Date: 8 November 2021

Our Reference: EN010095

Application by Boston Alternative Use Boston Projects for a Development Consent Order granting Development Consent for The Boston Alternative Energy Facility at Riverside Industrial Estate, Boston

The Examining Authority's written questions responses -

View 3: Photomontage view of the proposed Facility at Year 1

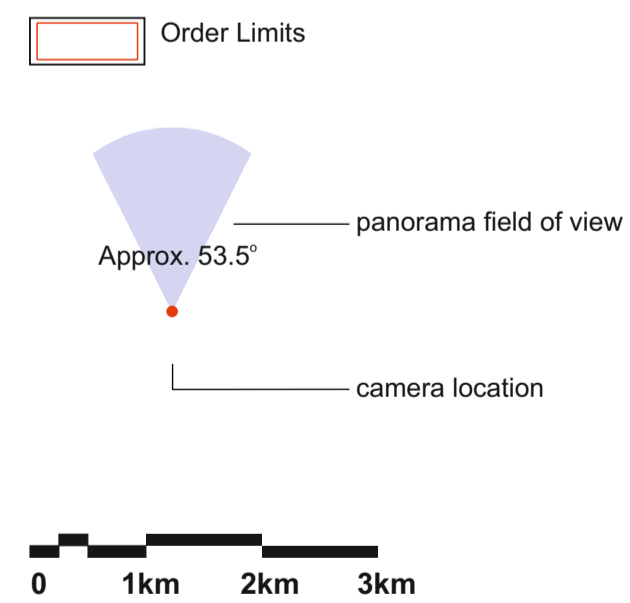
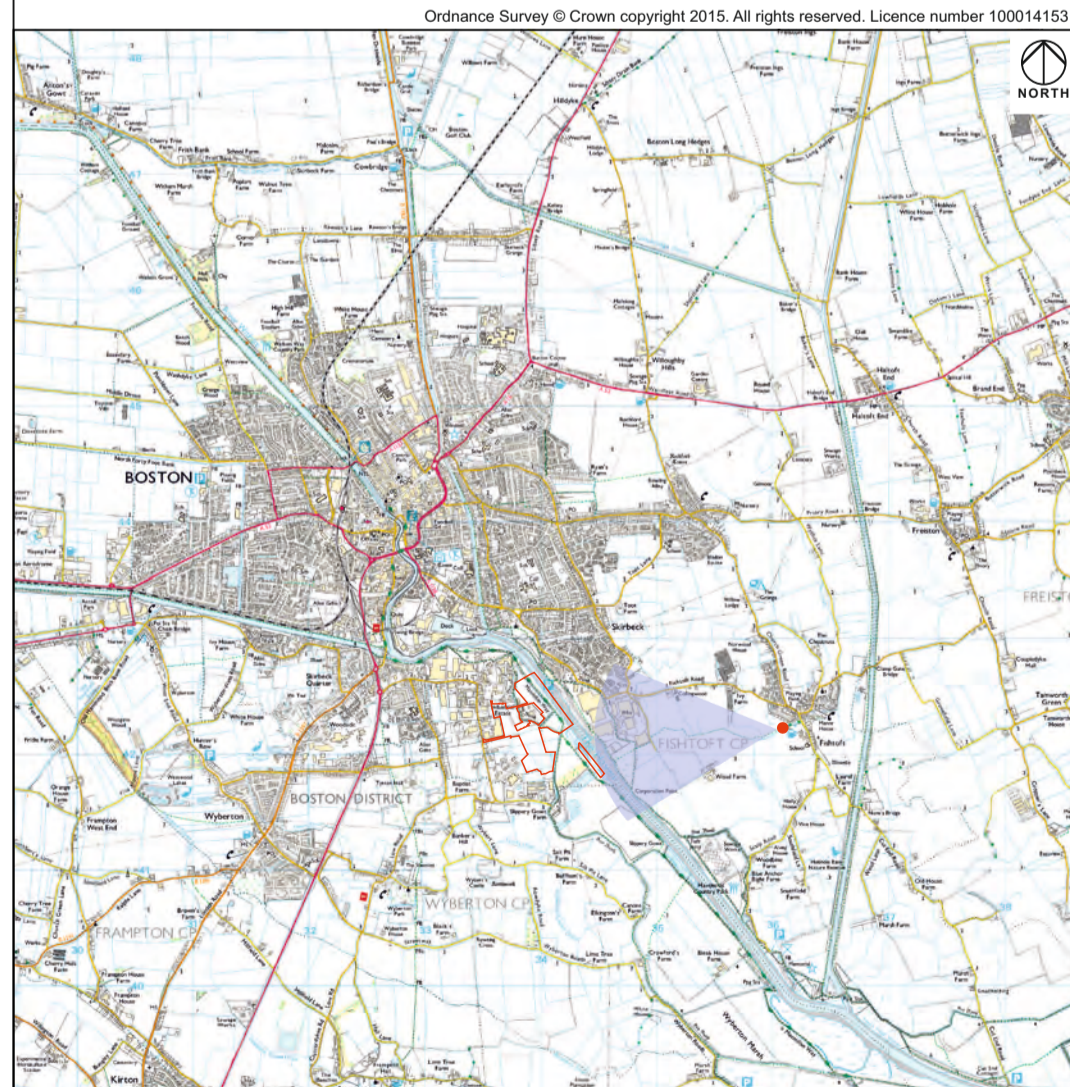
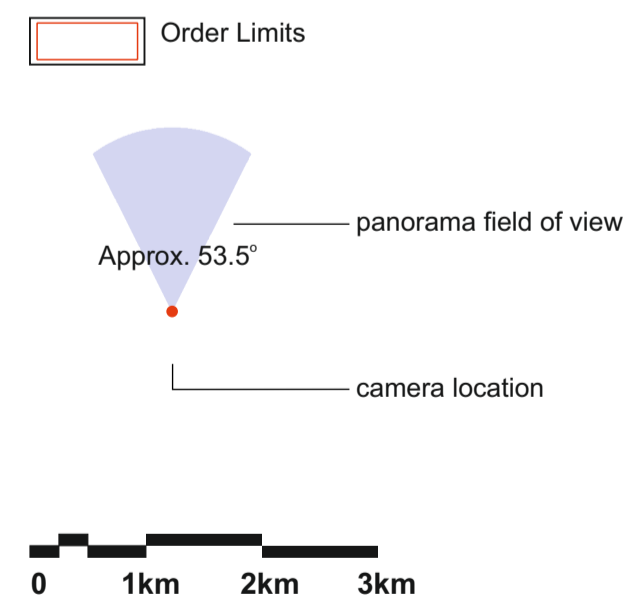
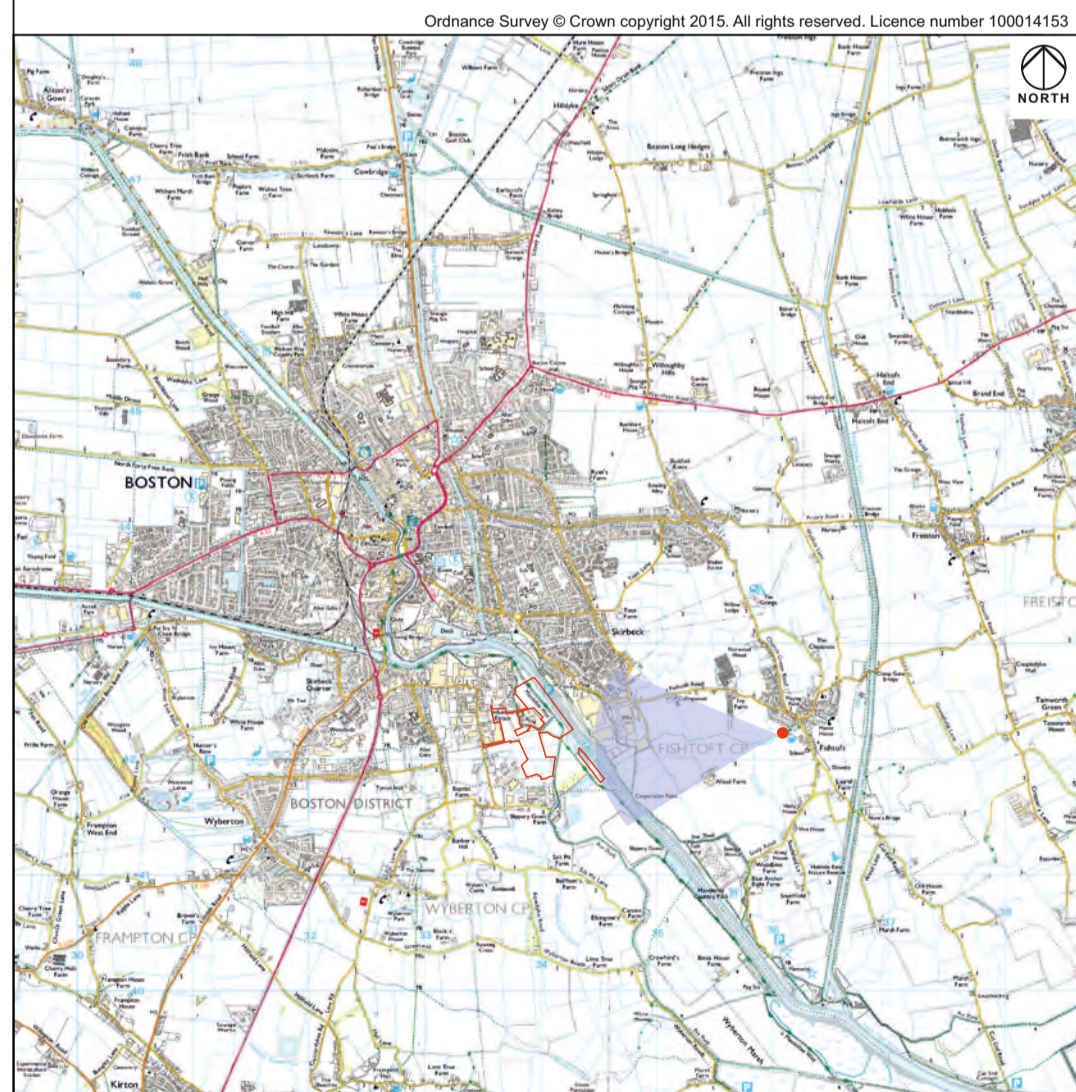
Q9.0.2 – 'The South-East Lincolnshire Local Plan states that development must "not obstruct a public view of St Botolph's church, Boston or challenge the visual dominance of the church". Are the stack heights proposed acceptable to LCC.'

LCC are not greatly concerned from a heritage setting perspective regarding the proposed stack height. It is noted, and accepted, that there will be some obstruction from some view points to the view of St Botolph's Church. However, it is felt that the applicant has given adequate weight and mitigation to this and given the industrial landscape including electricity pylons the stack heights are acceptable .
